DRB CASE ACTION LOG - BLUE SHEET

Project #: 1008961 Application #: 11DRB-70338
Project Name: Tracts 28-B-7-A
Agent: SBS Construction Phone #:

Your request was approved on 1-25-12 by the DRB with delegation of signature(s) to the following departments - outstanding comments to be addressed

PLAT OF
 LOTS 1 AND 2
 LANDS OF CHACON

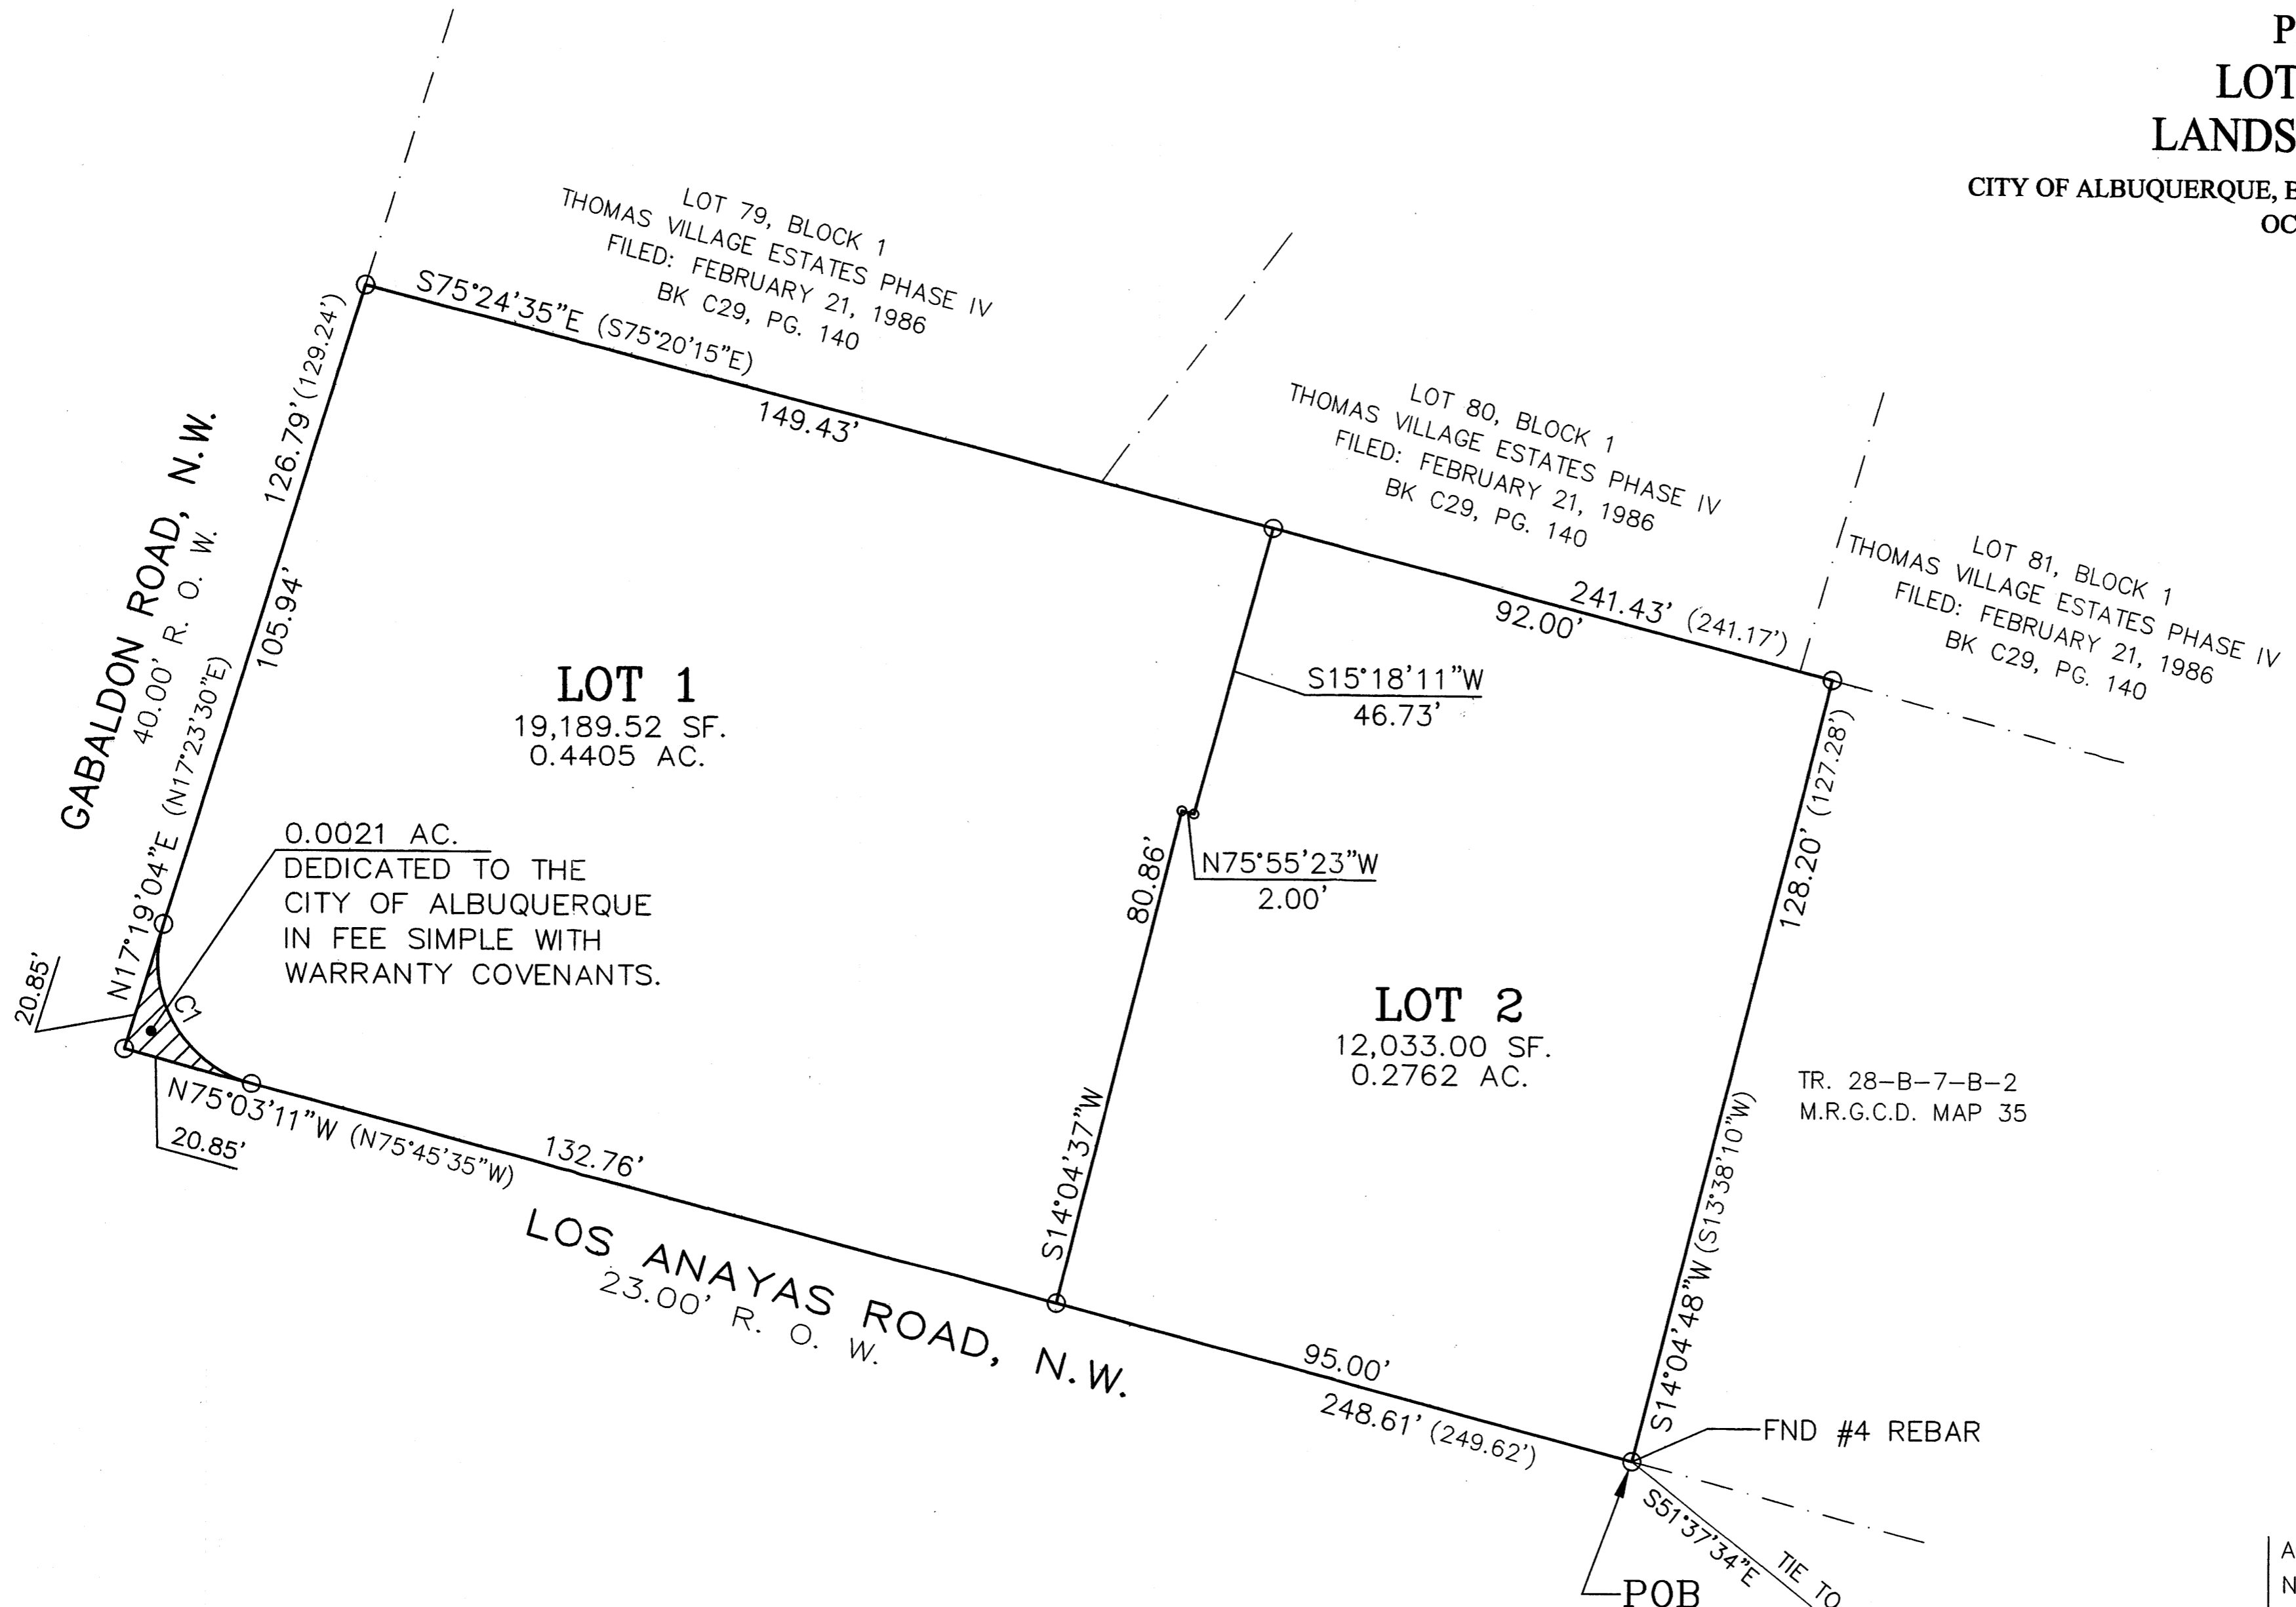
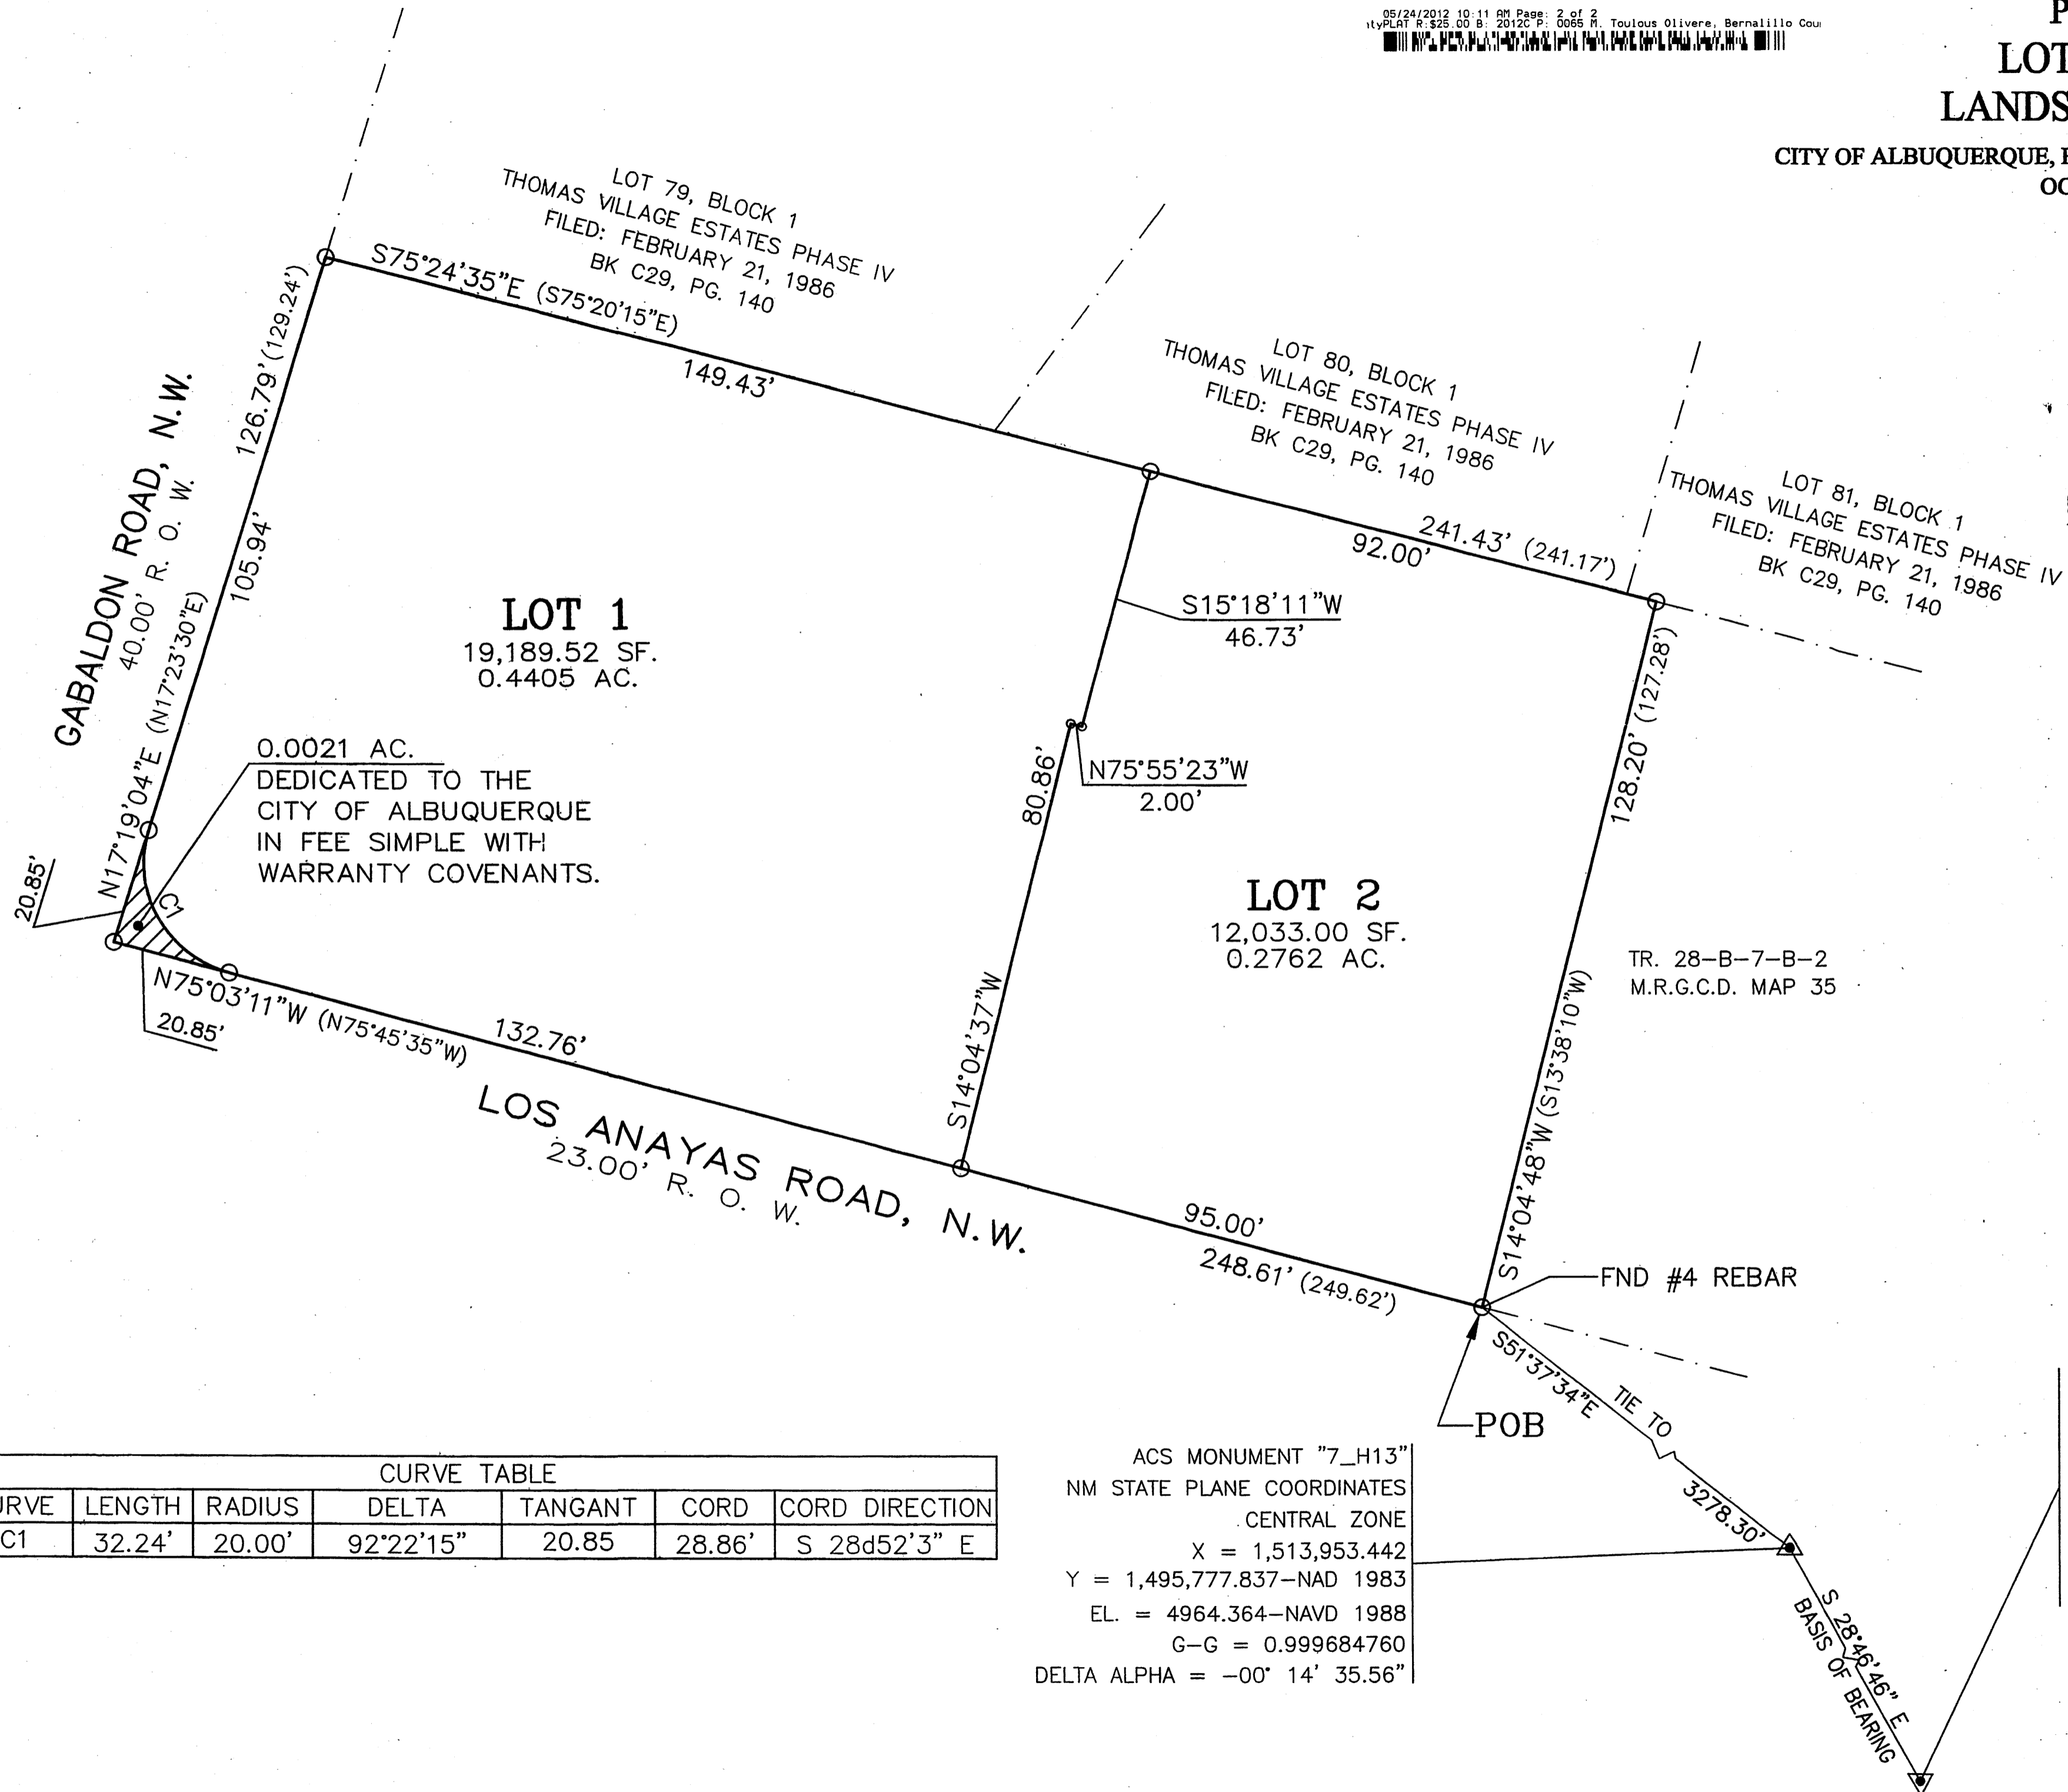
PLANNING (Last to sign): require Vicinity Map with larger font size

- TRANSPORTATION:
- ABCWUA:
- CITY ENGINEER / AMAFCA:
- PARKS / CIP:
- PLANNING (Last to sign): larger font on vicinity map
